KITTTITAS COUNTY COMMUNITY DEVELOPMENT SERVICES

Subject: Rampart Row Short Plat Final (SPF-20-00001) – Staff Review and Request for Additional Information

KITITITAS COUNTY		WASHINGTON	
DWN BY	DATE	JOB NO.	
G.W.	02/2020	19026	
CHKD BY	SCALE	SHEET	
M.K.K./D.L.P.	1" = 200'	1 OF 4

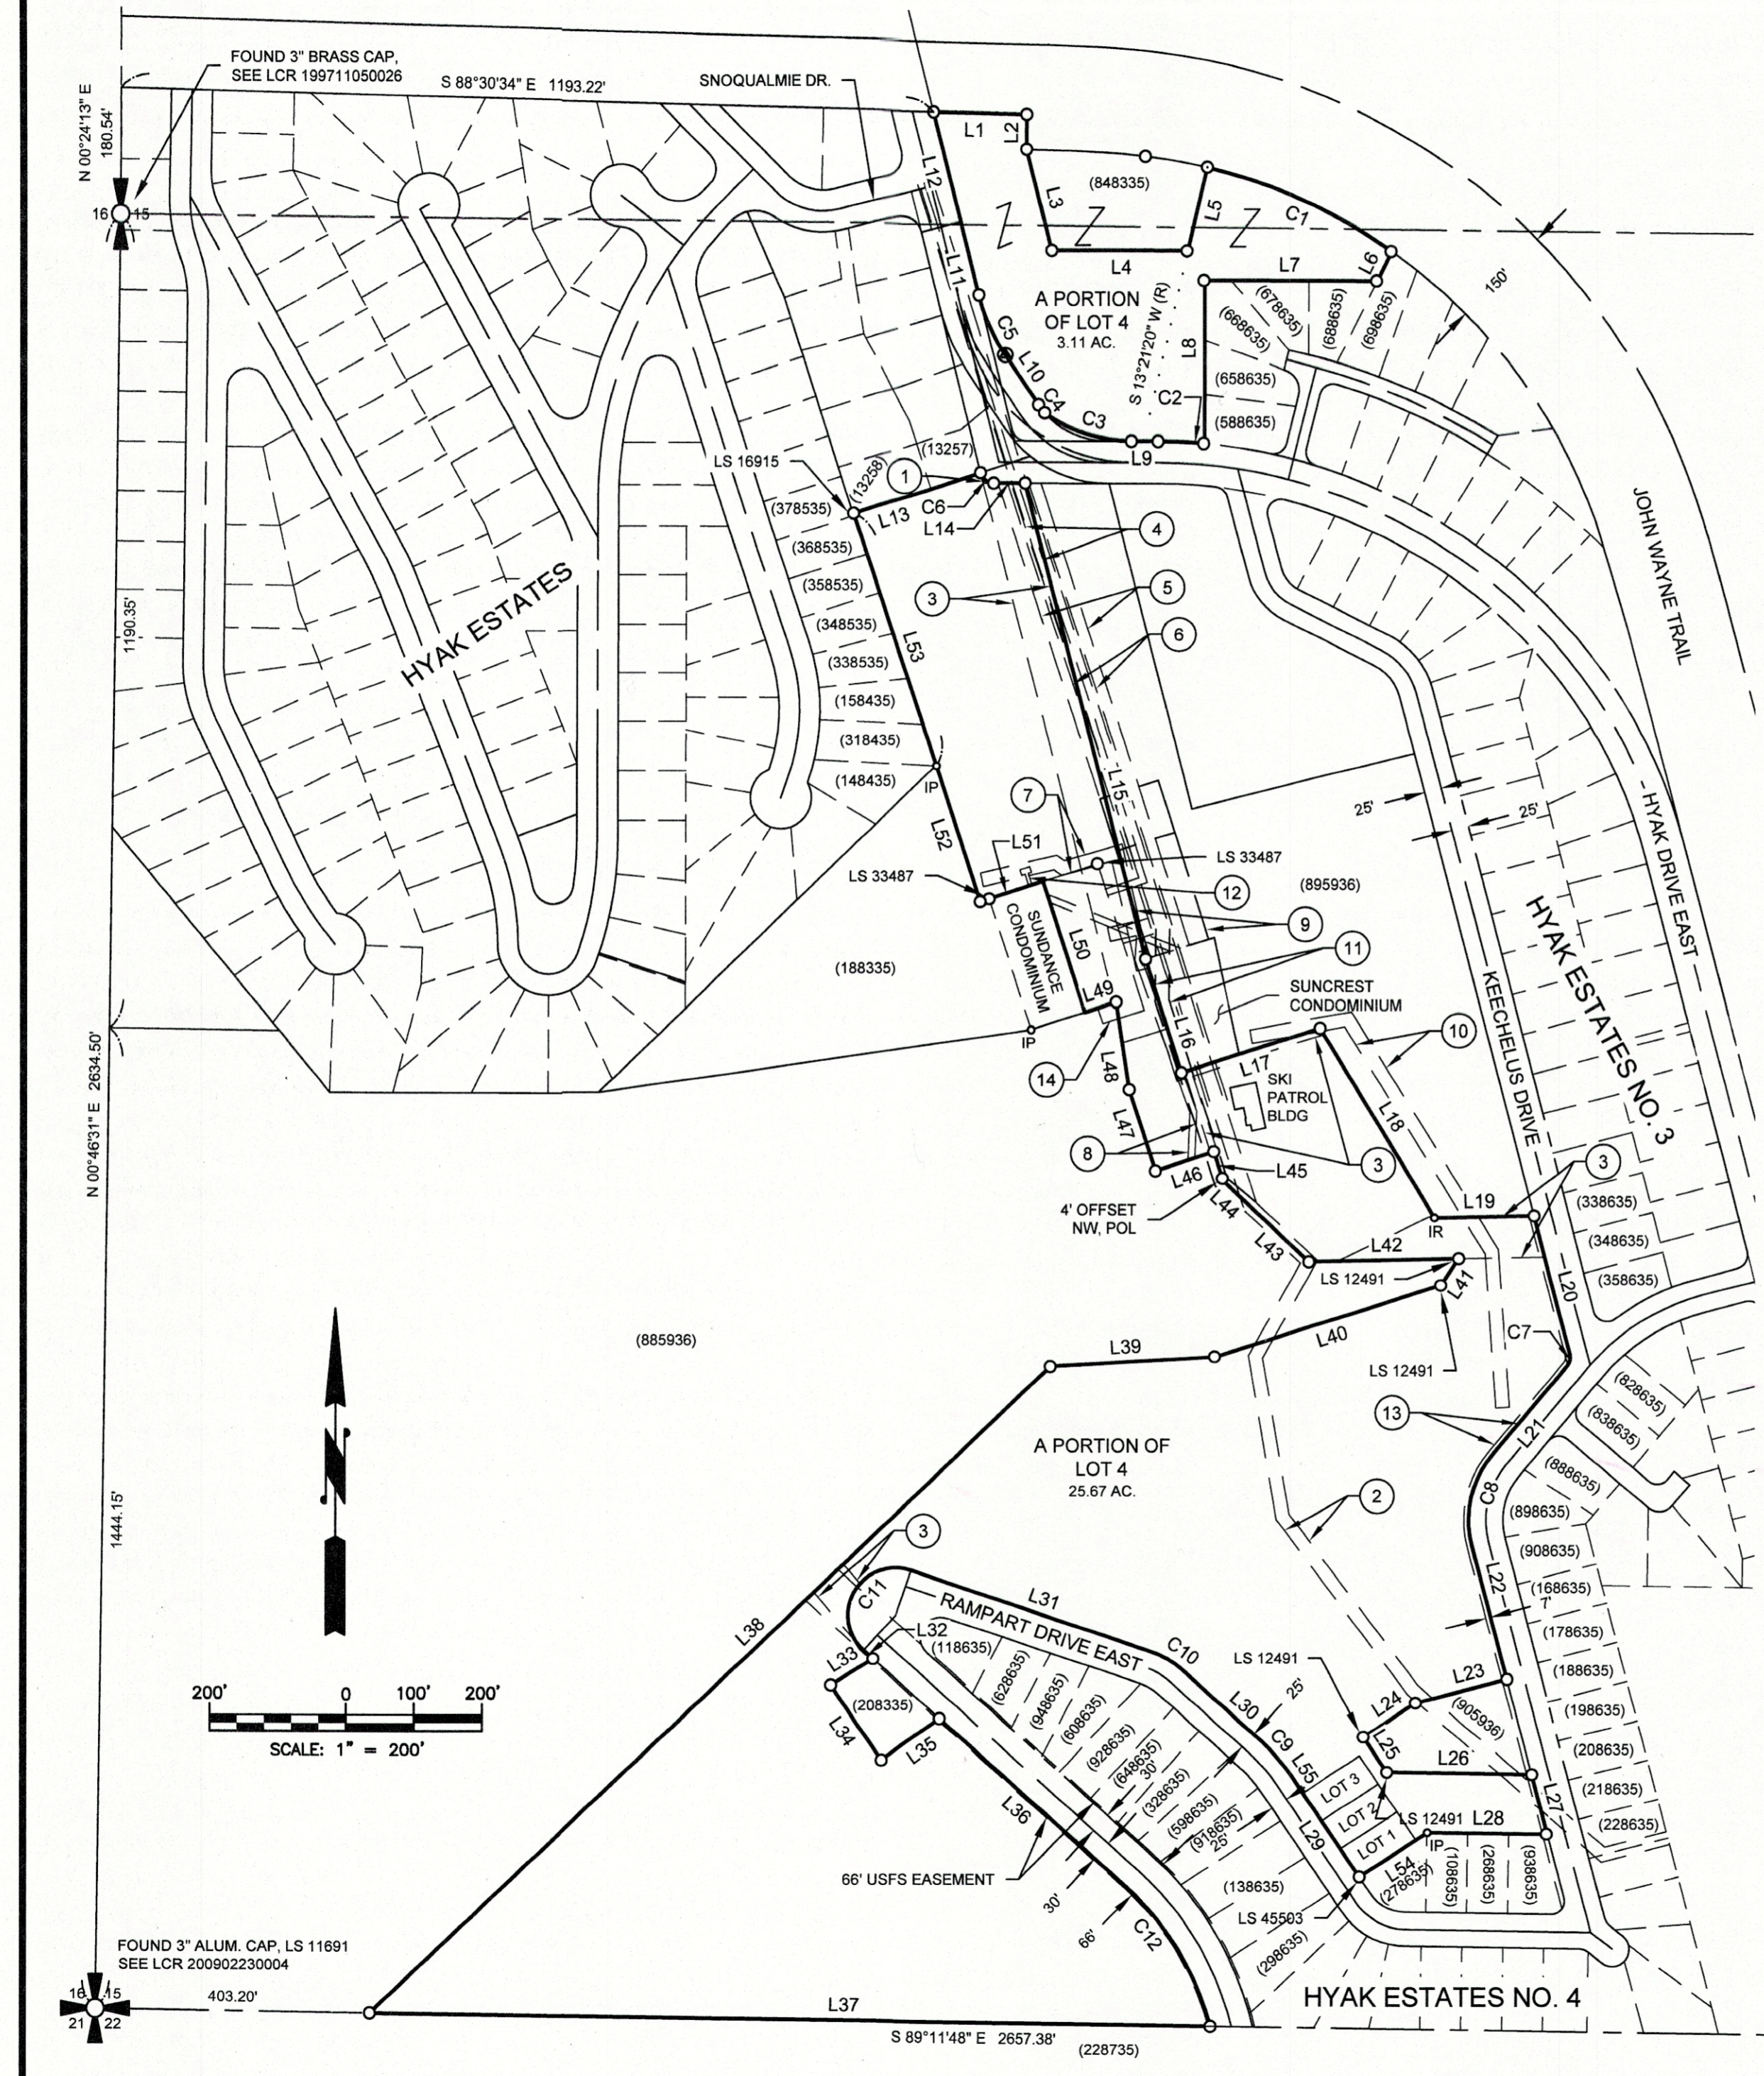
- The final short plat number "SPF-20-00001" shall also be present on the face of the plat and located directly above or below the SP-19-00002 already shown.
